From: Bruce Taunton <Bruce.Taunton@arun.gov.uk>
Sent: 26 May 2021 14:35
To: Planning.Responses <Planning.Responses@arun.gov.uk>
Subject: RE: Planning Consultation on: AB/61/21/L

Application No: AB/61/21/L

Registered: 28th April 2021
Site Address: 61 Maltravers Street Arundel BN18 9BQ
Grid Reference: 501542 106992
Description of Works: Listed building consent to reduced chimney height.

EXISTING ROOF PLAN

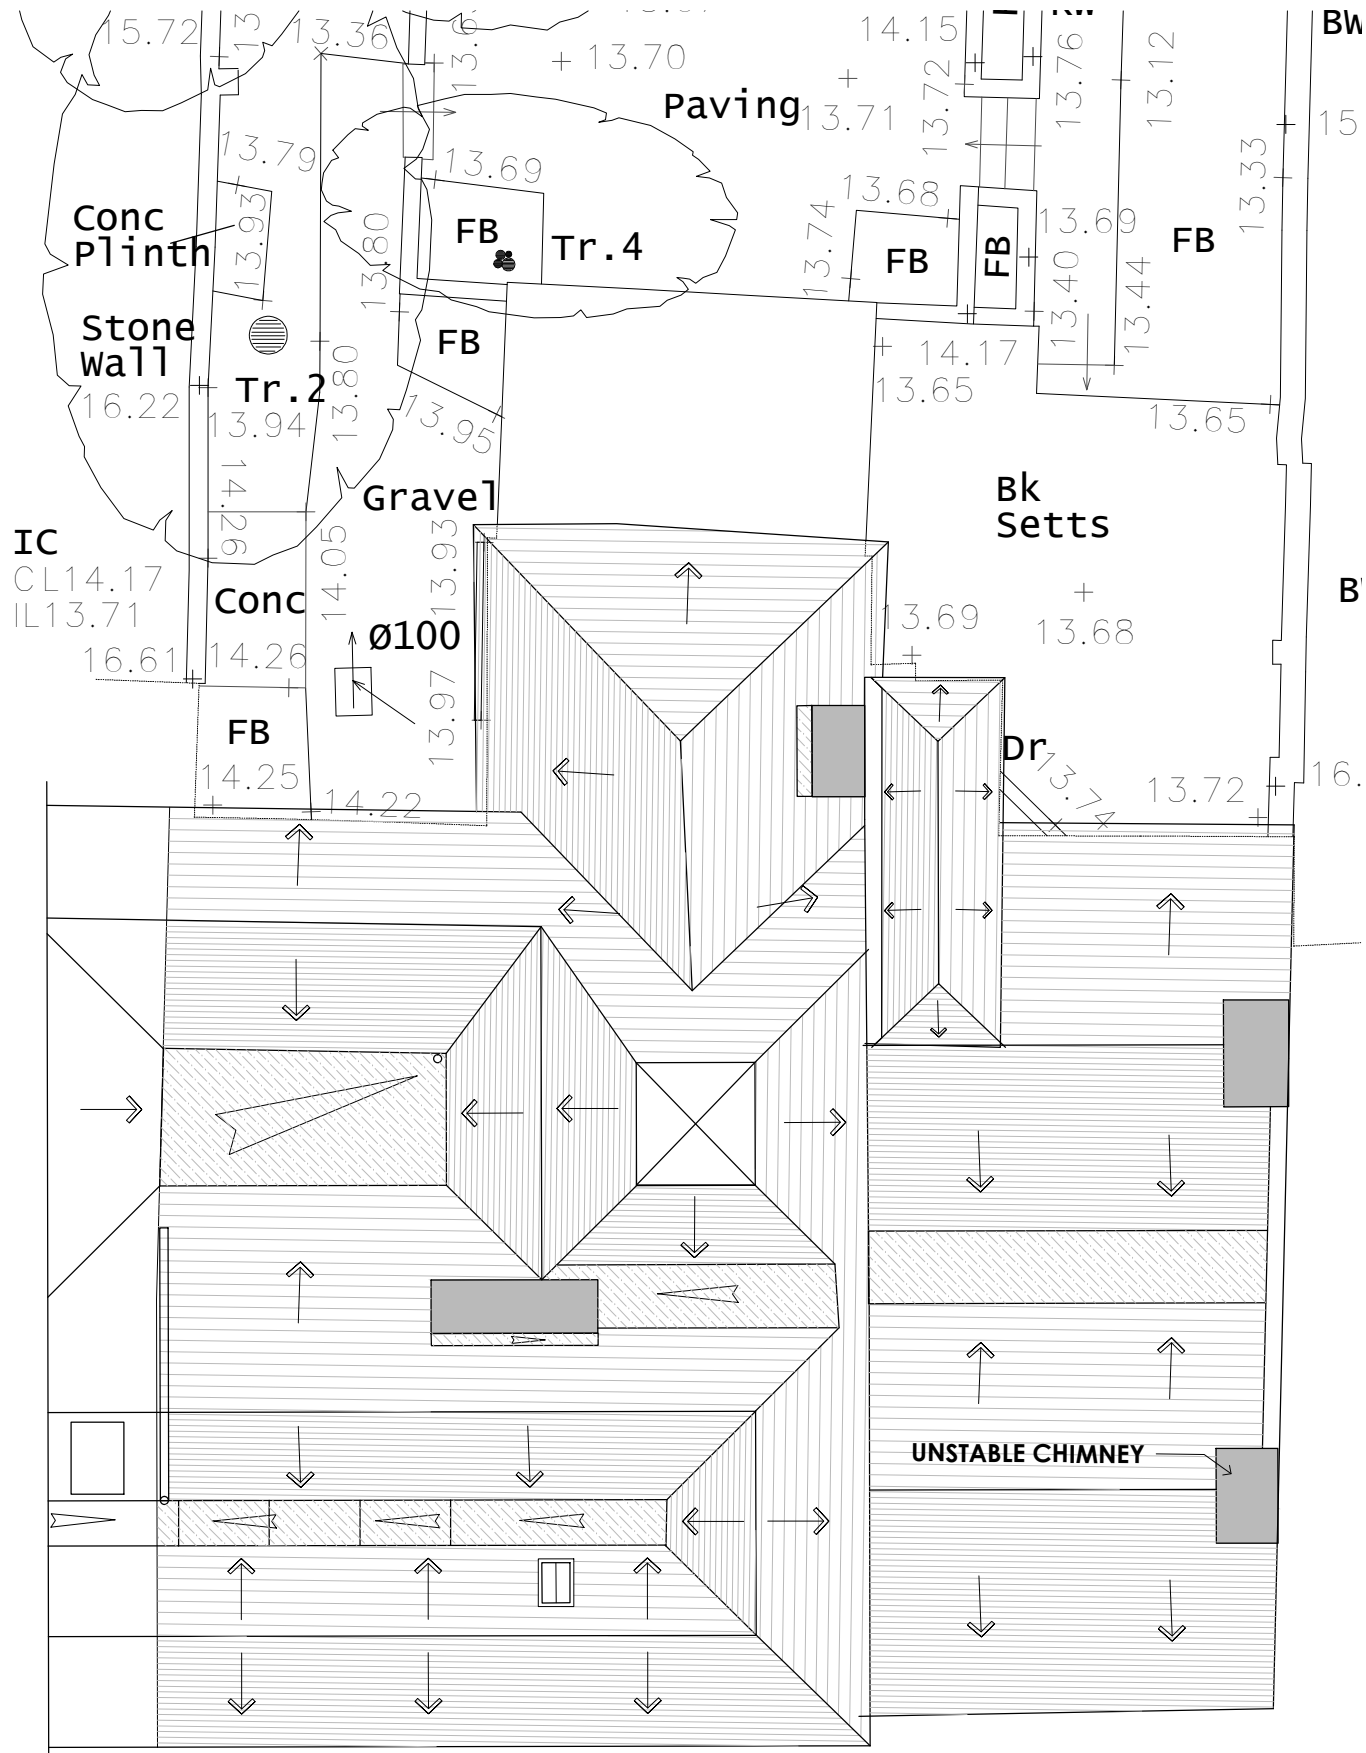
I have read through the reports and information and agree that a reduction in height based upon the requirements of the Building Regulations is required to maintain the safety of that element.
